**Report of the meeting of the Development Control Post-Committee Site
Inspection Panel held on 20-03-2018**

REF NO: AW/328/17/OUT

LOCATION: 14 Princess Avenue
Aldwick

PROPOSAL: Outline application with some matters reserved for the conversion of existing dwelling into 5 self contained flats with front, rear, side & dormer extensions (resubmission following AW/71/17/OUT).

Site and Block Plan

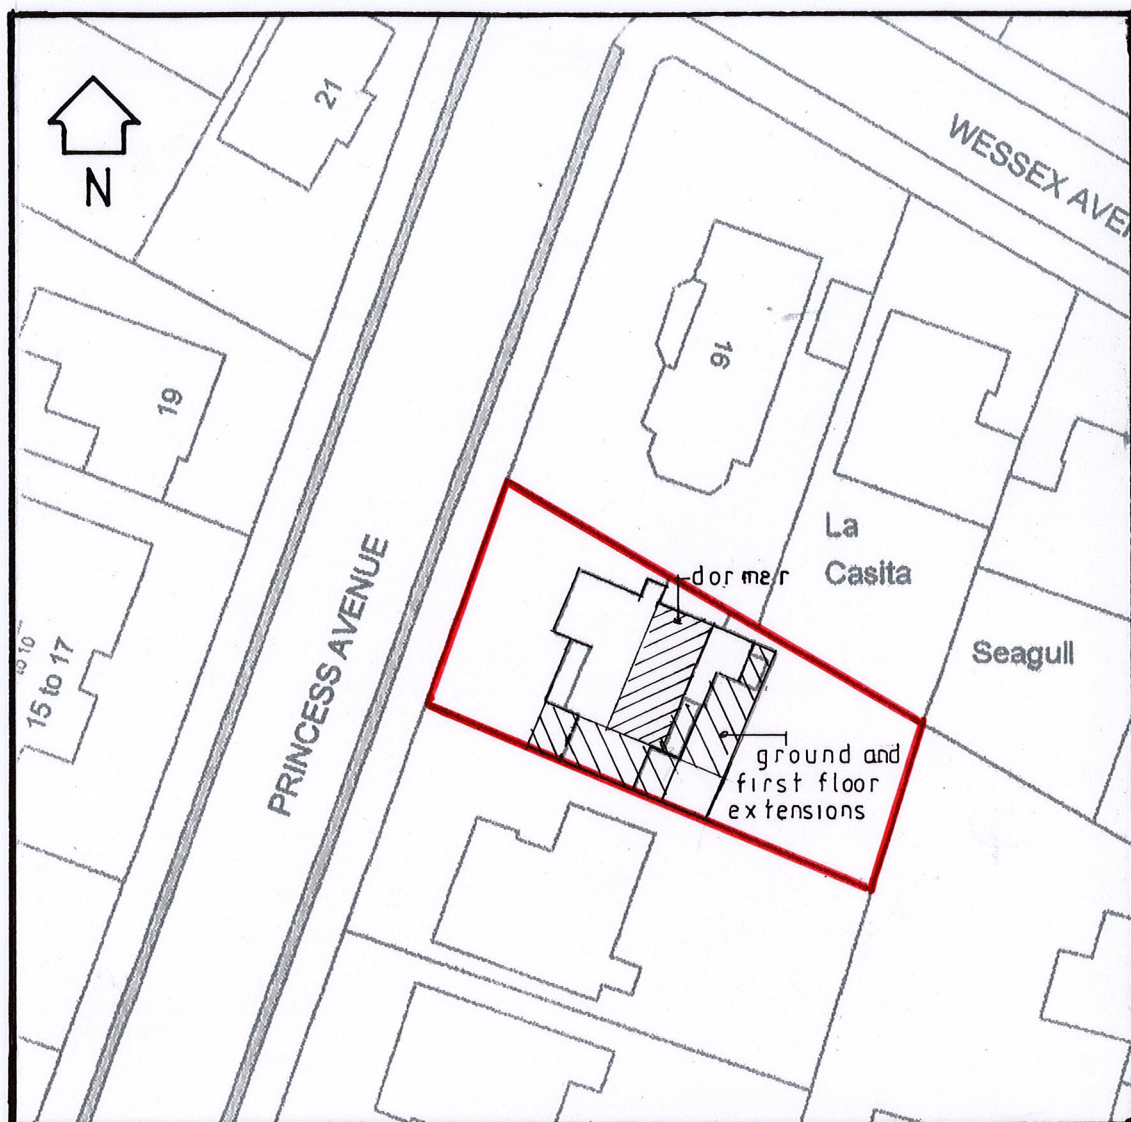
- (8) The access to the rear garden between the northern wall of the building and the boundary is less than 1m wide;
- (9) Inadequate access to the entrance to flat 2 for emergency fire/ambulance personnel;

- (7) It is not considered that the movements associated with the flat entrance would be materially different to the use of a back door by a resident;
- (8) According to the submitted site plan, the width is between 1 and 1.1m which would be sufficient. It is accepted that the width seems less when looking at the proposed ground floor plan but it is not considered that this straight line at the top of this plan is the line of the boundary;

Proposed Second
Floor Plan

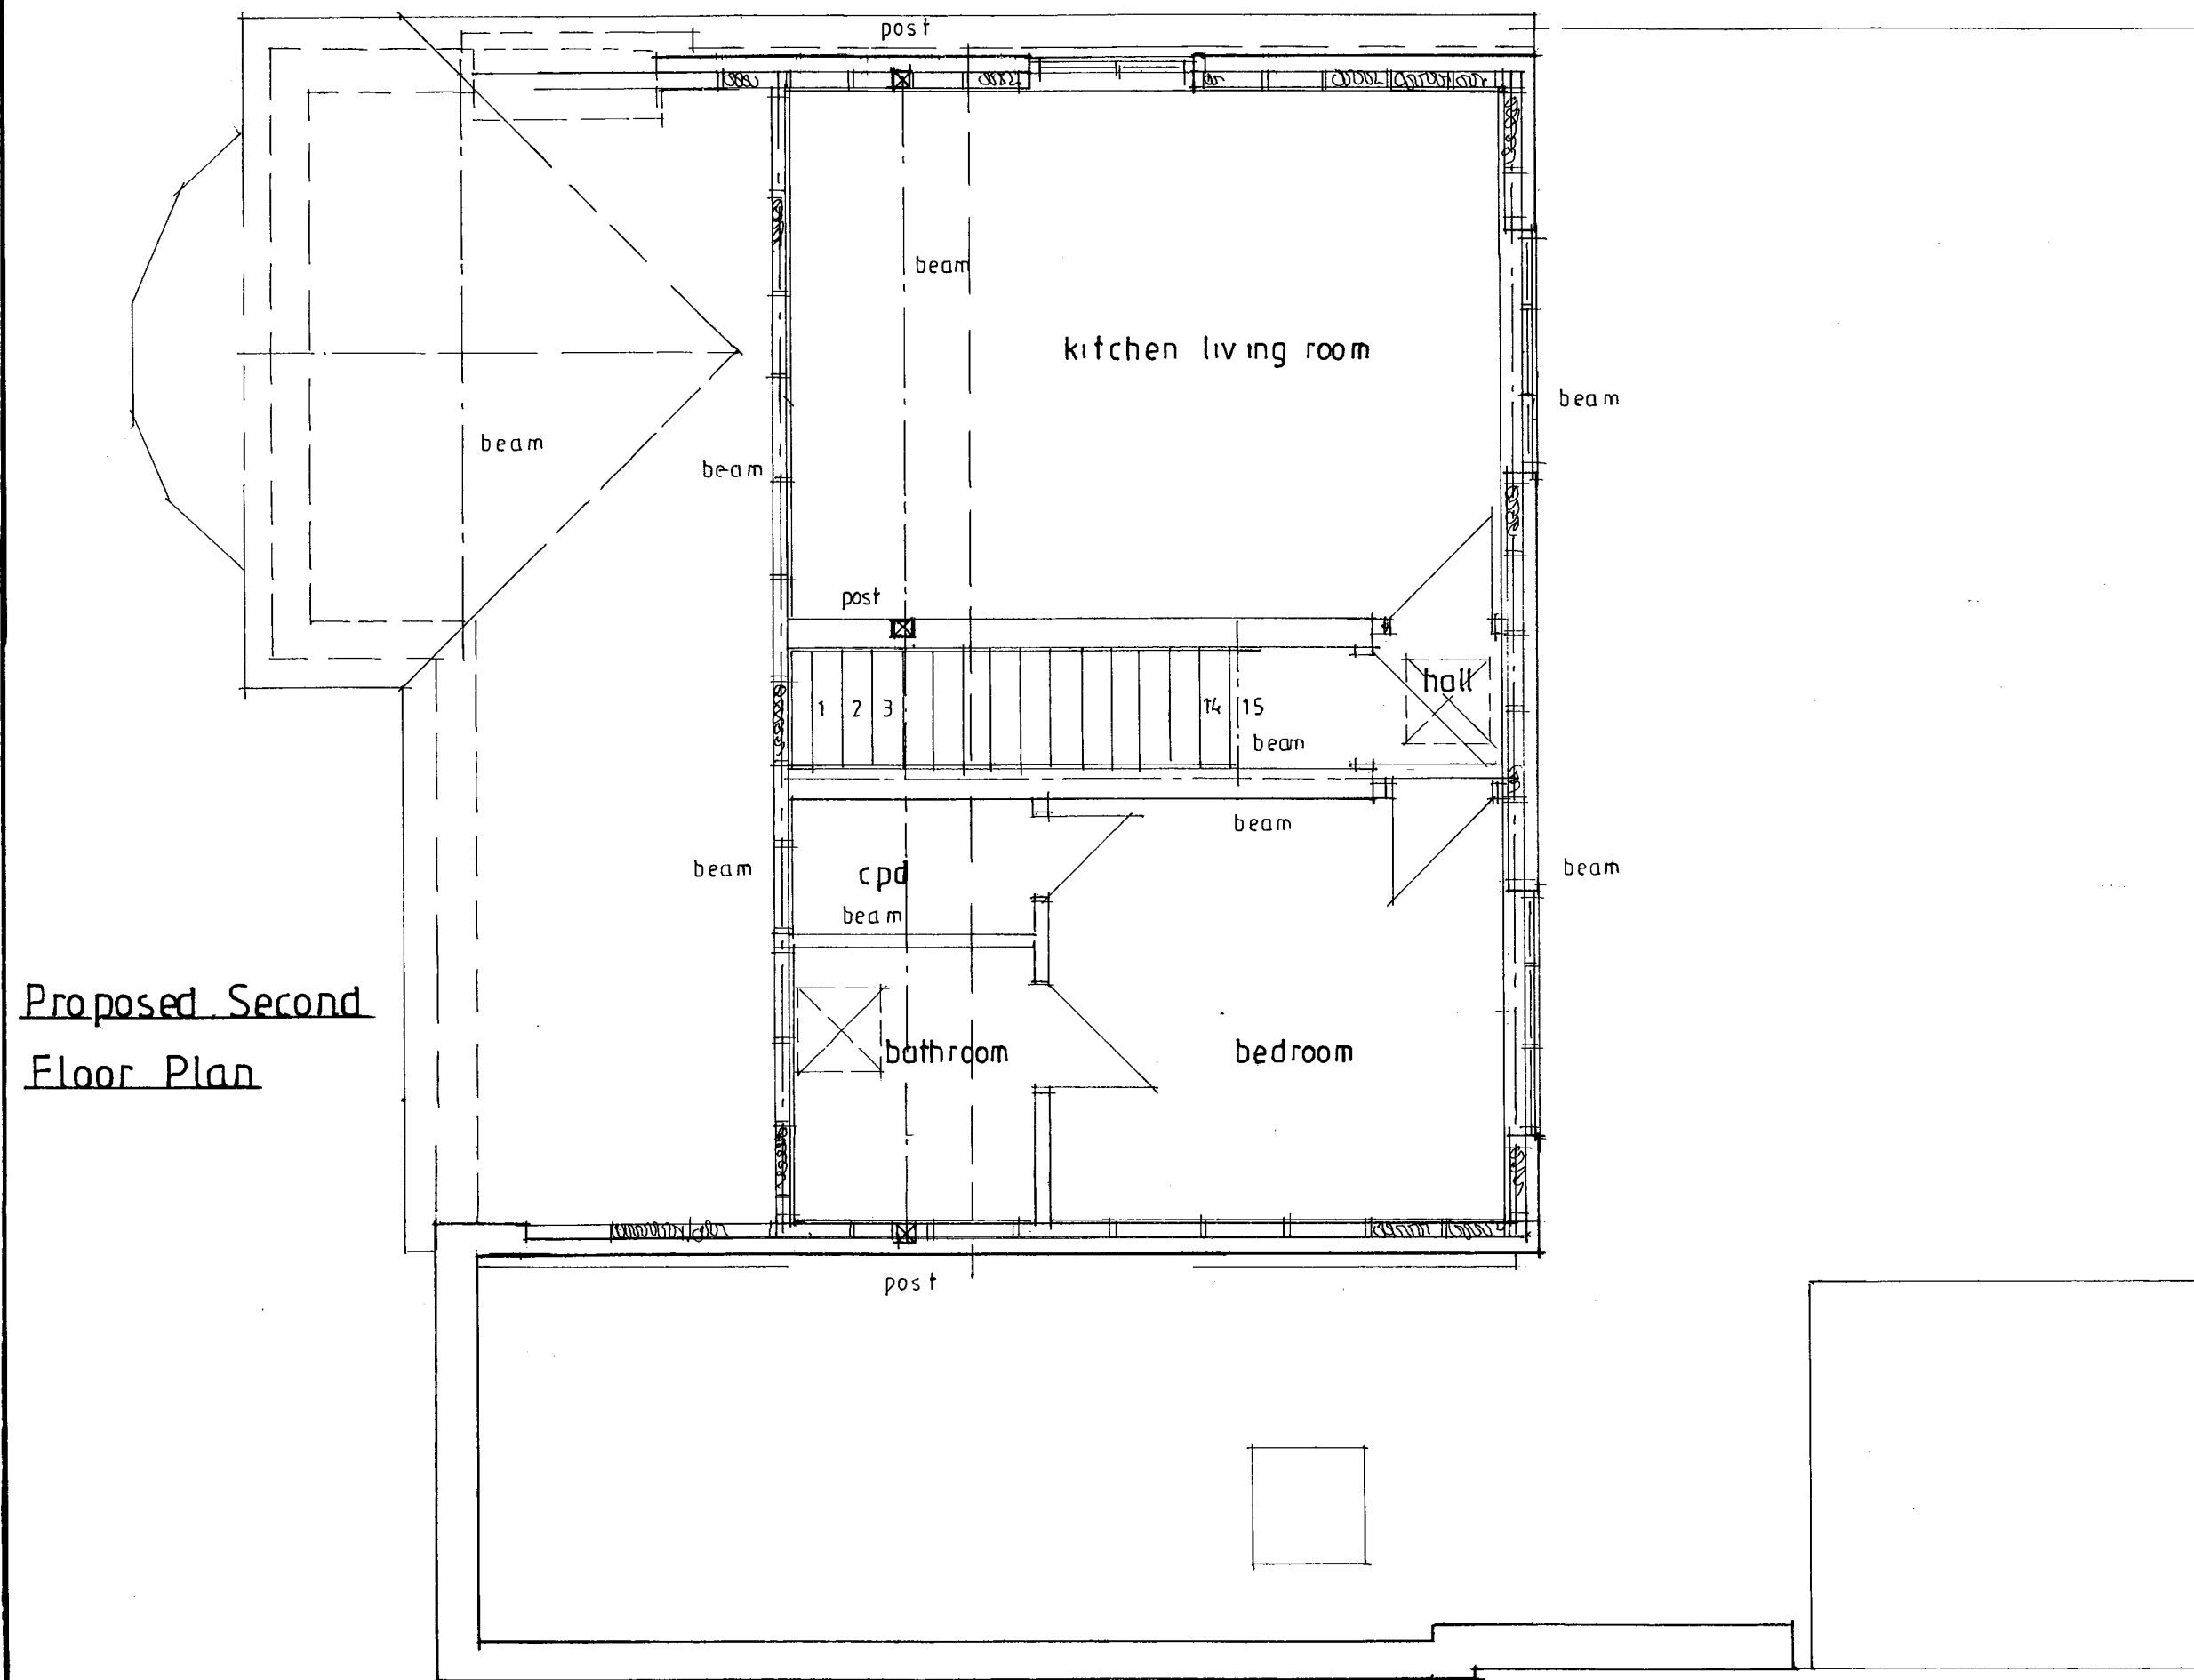
1	2B3P	61m2	60m2
2	2B3P	61m2	74m2
3	2B3P	61m2	57m2
4	2B3P	61m2	62m2
5	1B1P	39m2	36m2

Although the scheme is only 40% compliant it is considered that this is acceptable having regard to: (a) the preamble to Policy D DM2 of the emerging modified Local Plan which states that "There might be occasions where development schemes cannot comply with all the space standards required (such as the conversion of an existing building" and that these will be considered on a case-by-case basis; and (b) in the case of the 3 flats that do not comply, none are significantly less than the requirement. On this basis, it is considered that the proposal is in accordance with the emerging space standards policy.
